RE: 23/02716/DISC Discharge of Condition 5 (Site Development Scheme
of 20/02060/F (Appeal Ref APP/C3105/C/21/3268454
THE STABLES MAIN STREET GREAT BOURTON

DRAWING No. PBA 4

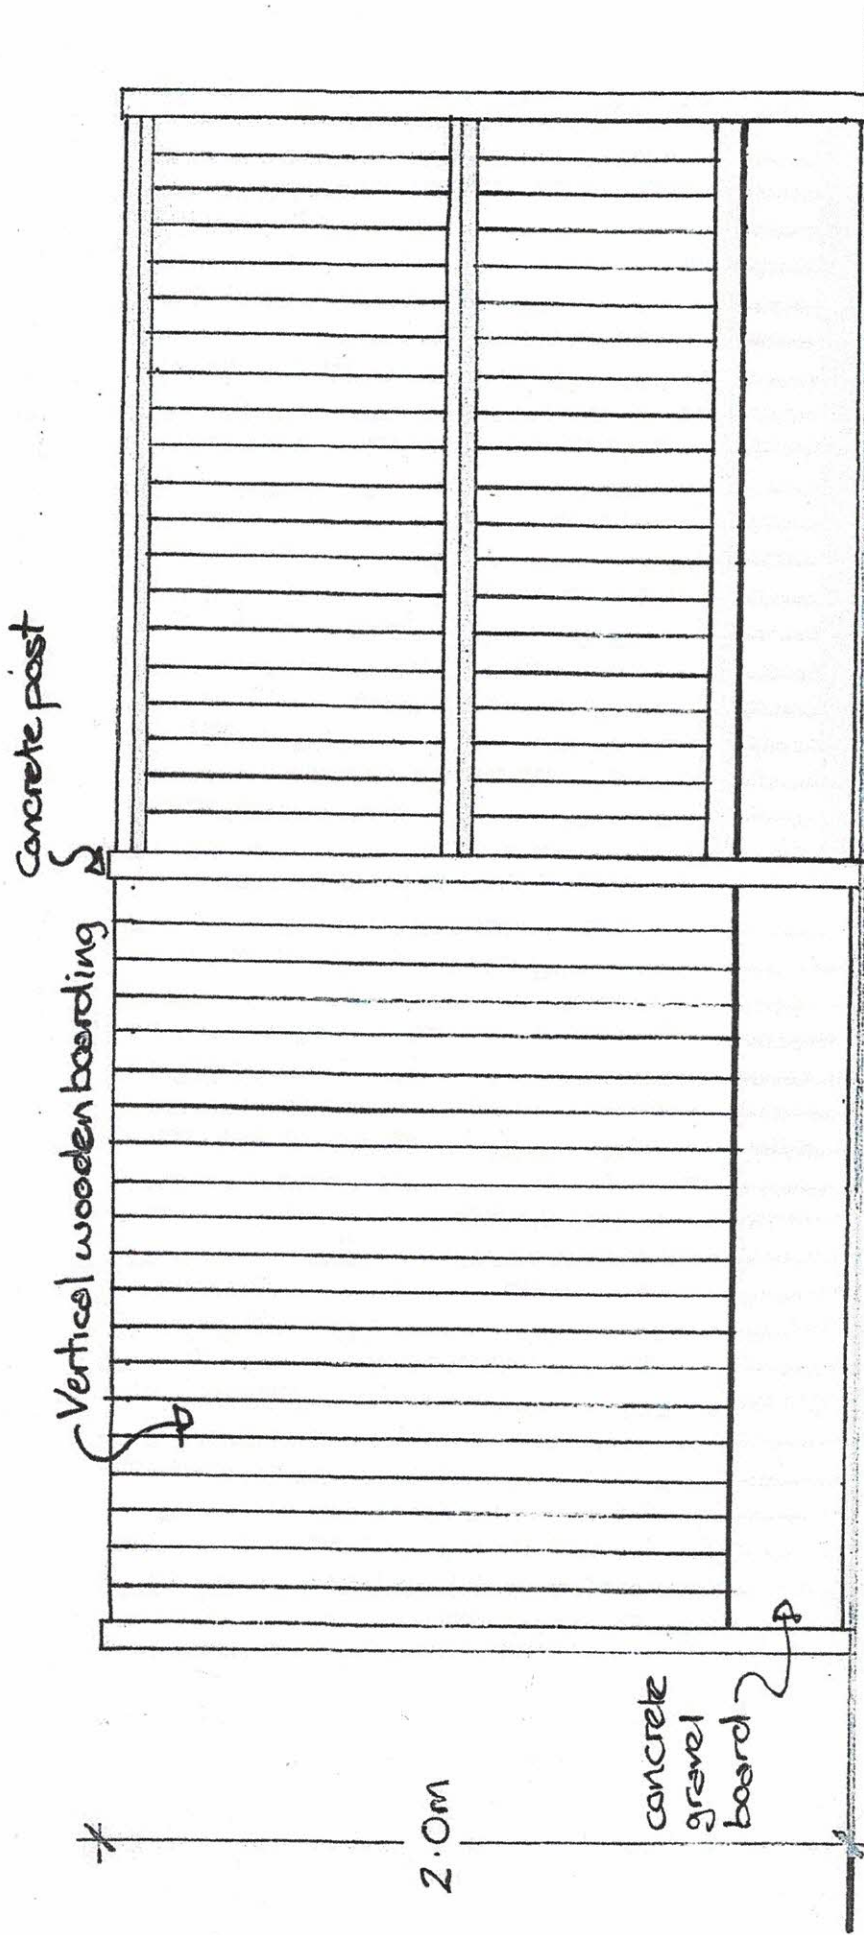
that was erected at the southern end of the site? The drawing for the close board fencing (PBA4) is the same as the one previously refused as “being a hard urban edge that would be seen from the public footpath” It also has a very urban appearance when looking down from Great Bourton!
